Site Address: 63 Annandale Avenue, Bognor Regis, PO21 2DN

Proposal: Demolition of existing Dwelling and erection of a three-storey building comprising nine self-contained flats.

I write to inform you that my wife and I formally object to this planning application.

| DRAWING<br>Proposed<br>Block Plan         |                  |

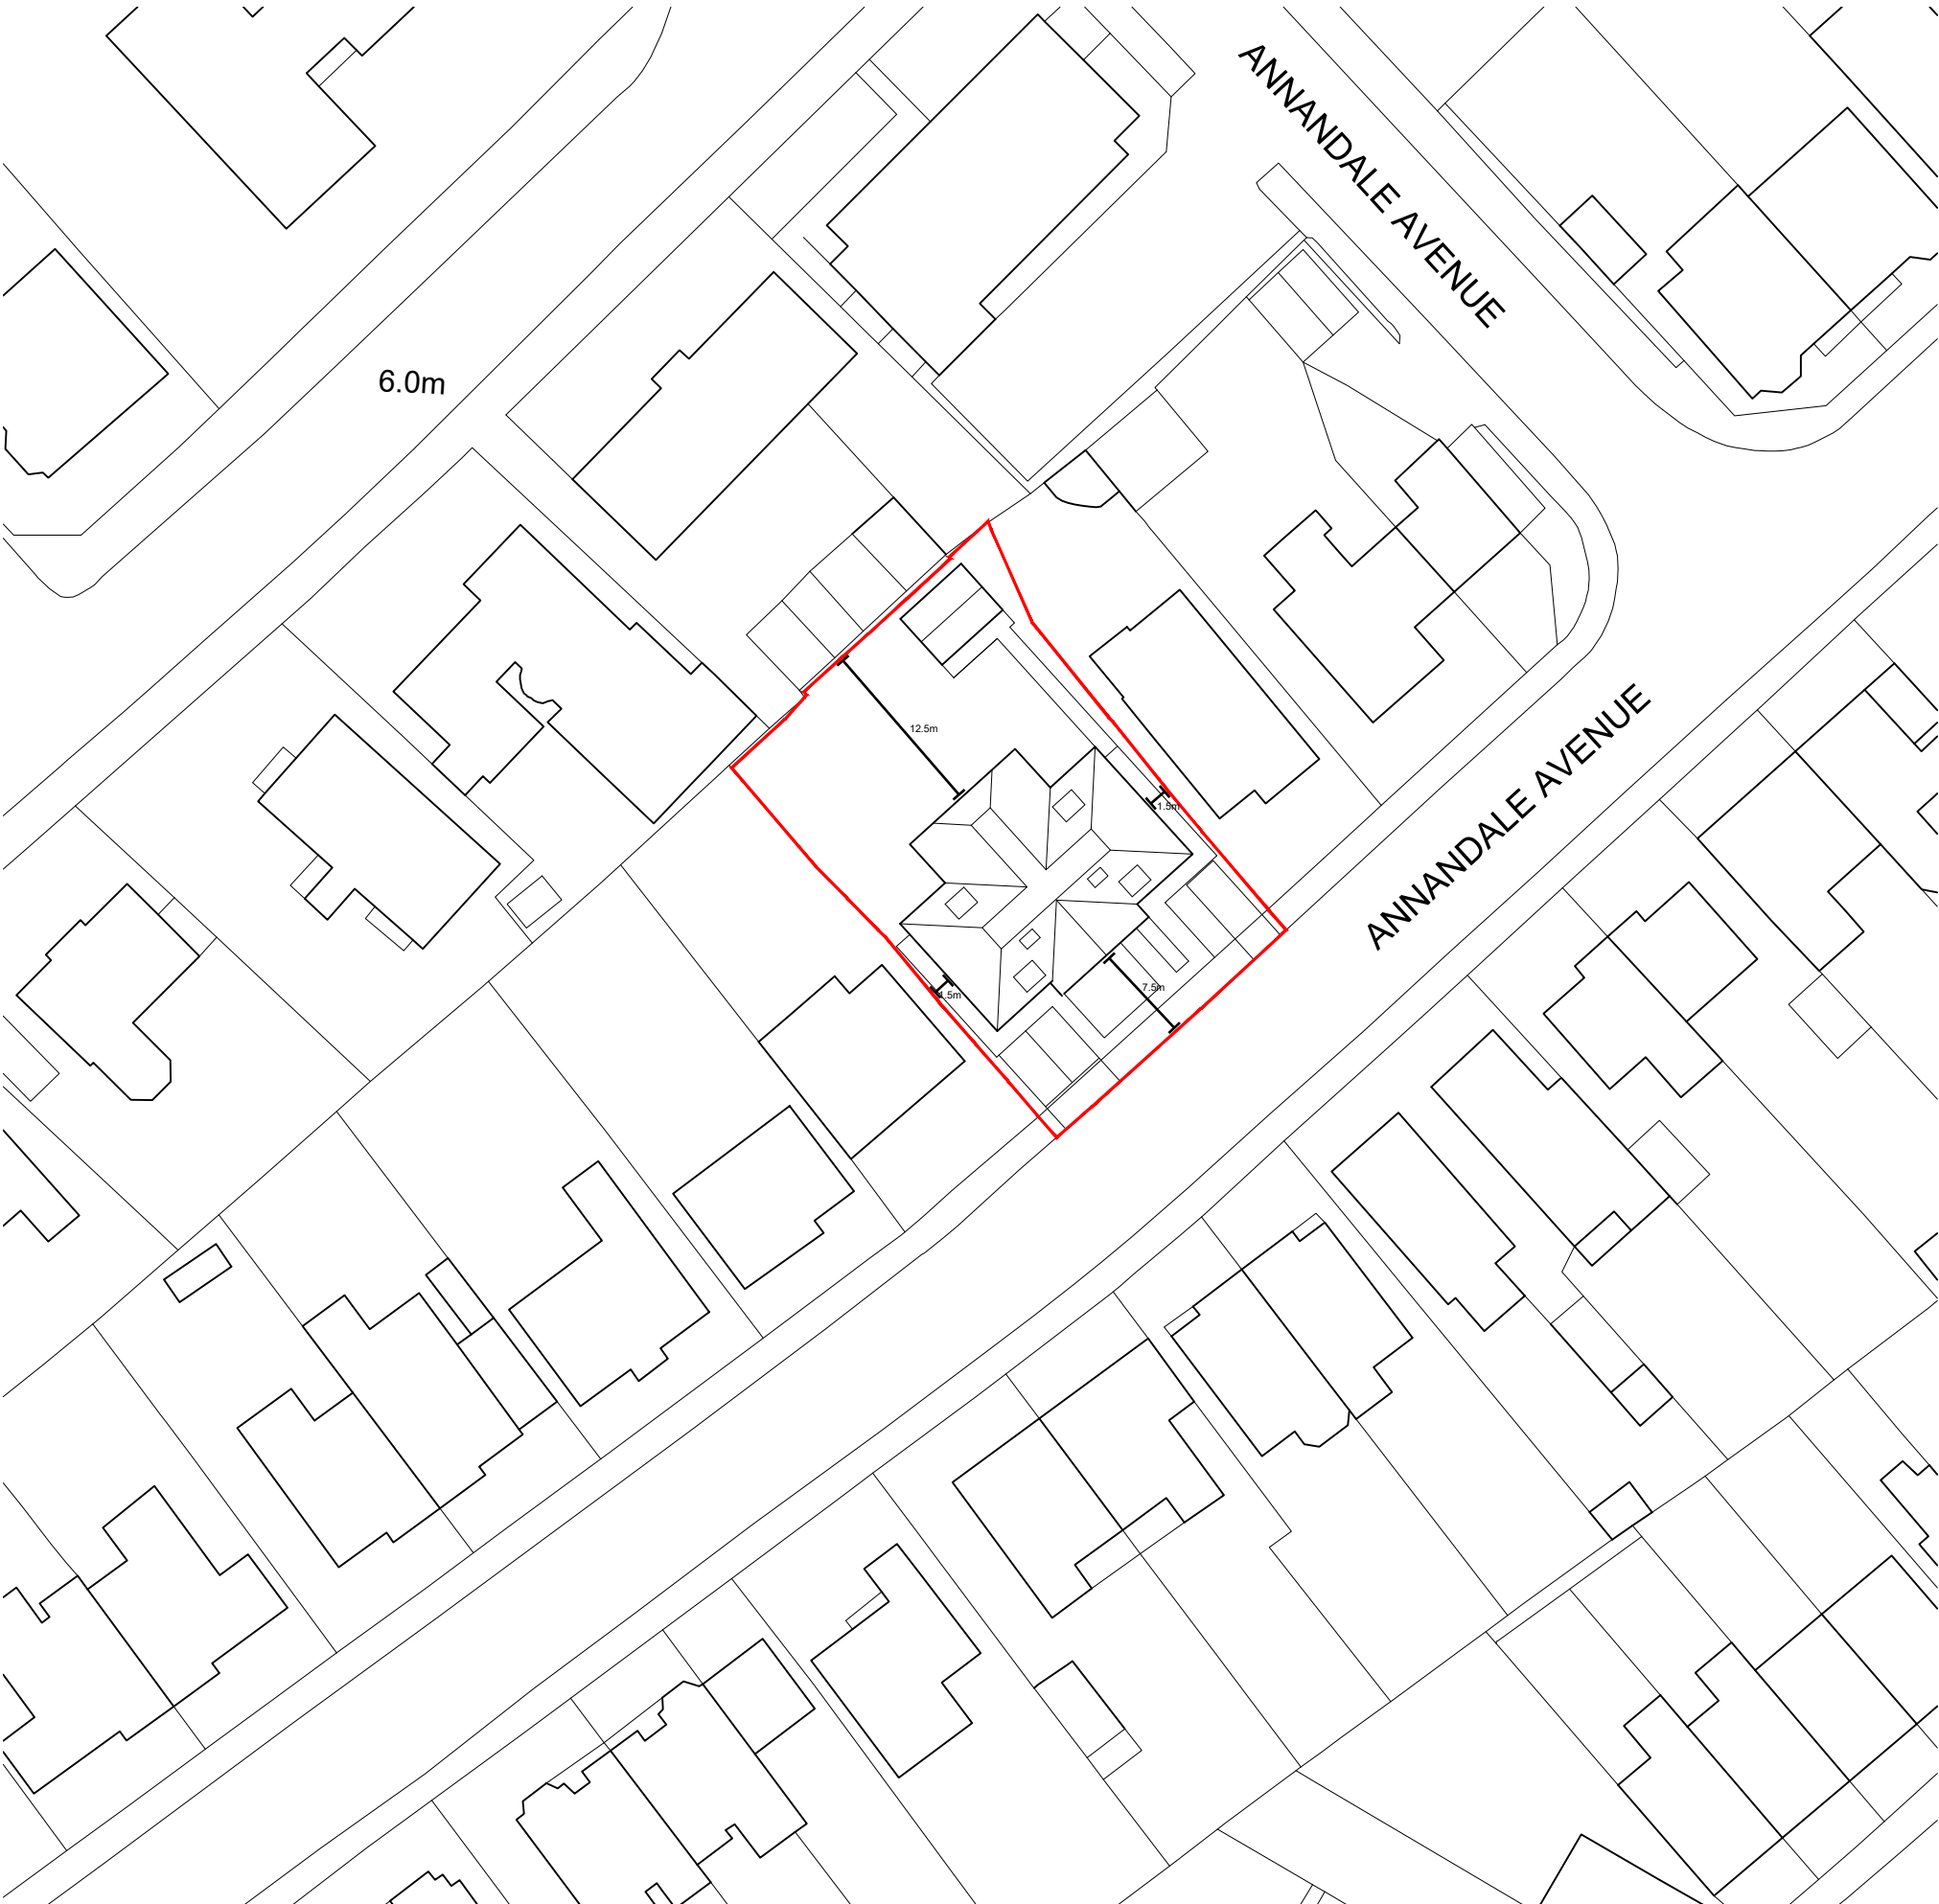
All the buildings nearby are 2 storey and of standard house design and what is proposed is out of all proportion in size, bulk, presence on the plot and intensity of occupation. This new development will also block out the natural light into our two lounge windows and first floor bathroom window.

We would also like to point out that parking on the road at this end of Annandale Avenue is proving to be increasingly difficult with more cars per house all the time. This is made worse by people parking on our road by staff from the nearby vets and other people also parking on our road from out of the area to use the train. The existing house has at present off-road parking for easily 5 cars and parking on the road outside allows another two car parking spaces. The new development is only allowing for 3 off road parking and will also mean the loss of the 2 road spaces making it worse for us all who have cars.

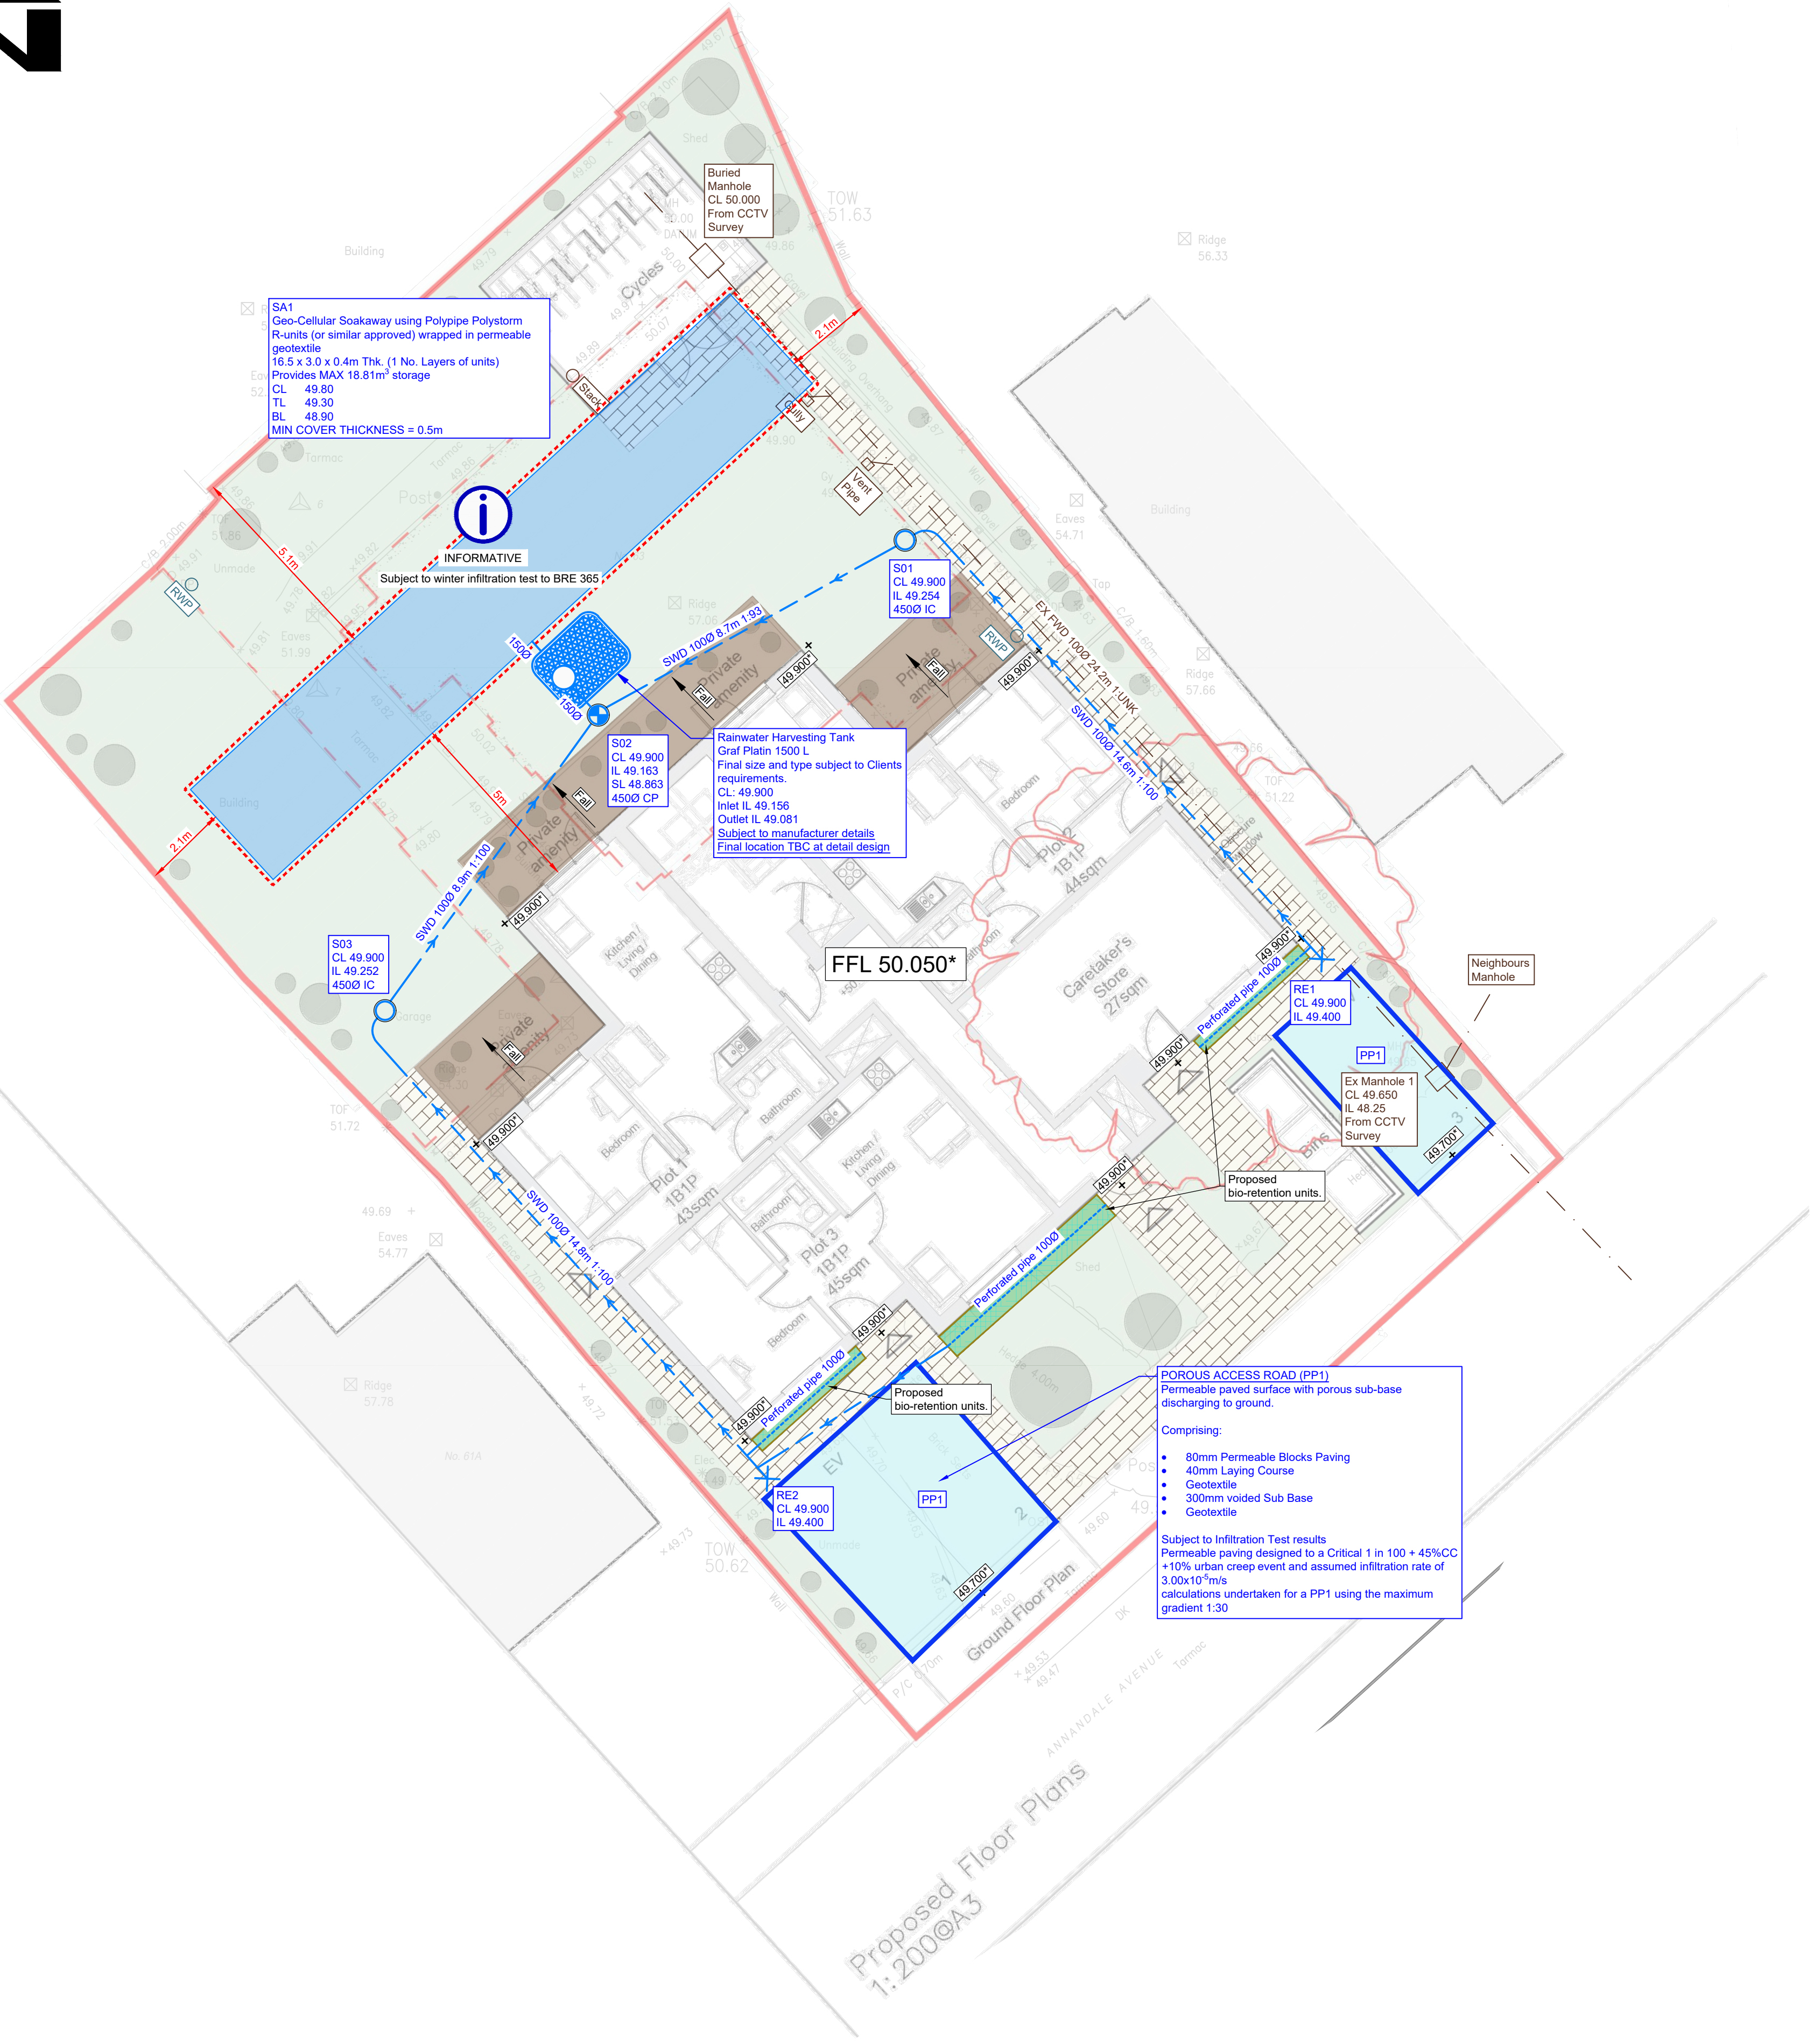
We must also state our concerns that our foul drainage is linked to the main drain run of 63 Annandale Avenue and we have had to unblock this foul drain run at the manhole where it runs into the main road sewer 7 times since we have lived here, and to now have another extra 8 bathrooms and kitchen foul drainage being linked to this run is in our opinion going to overload the foul drainage.
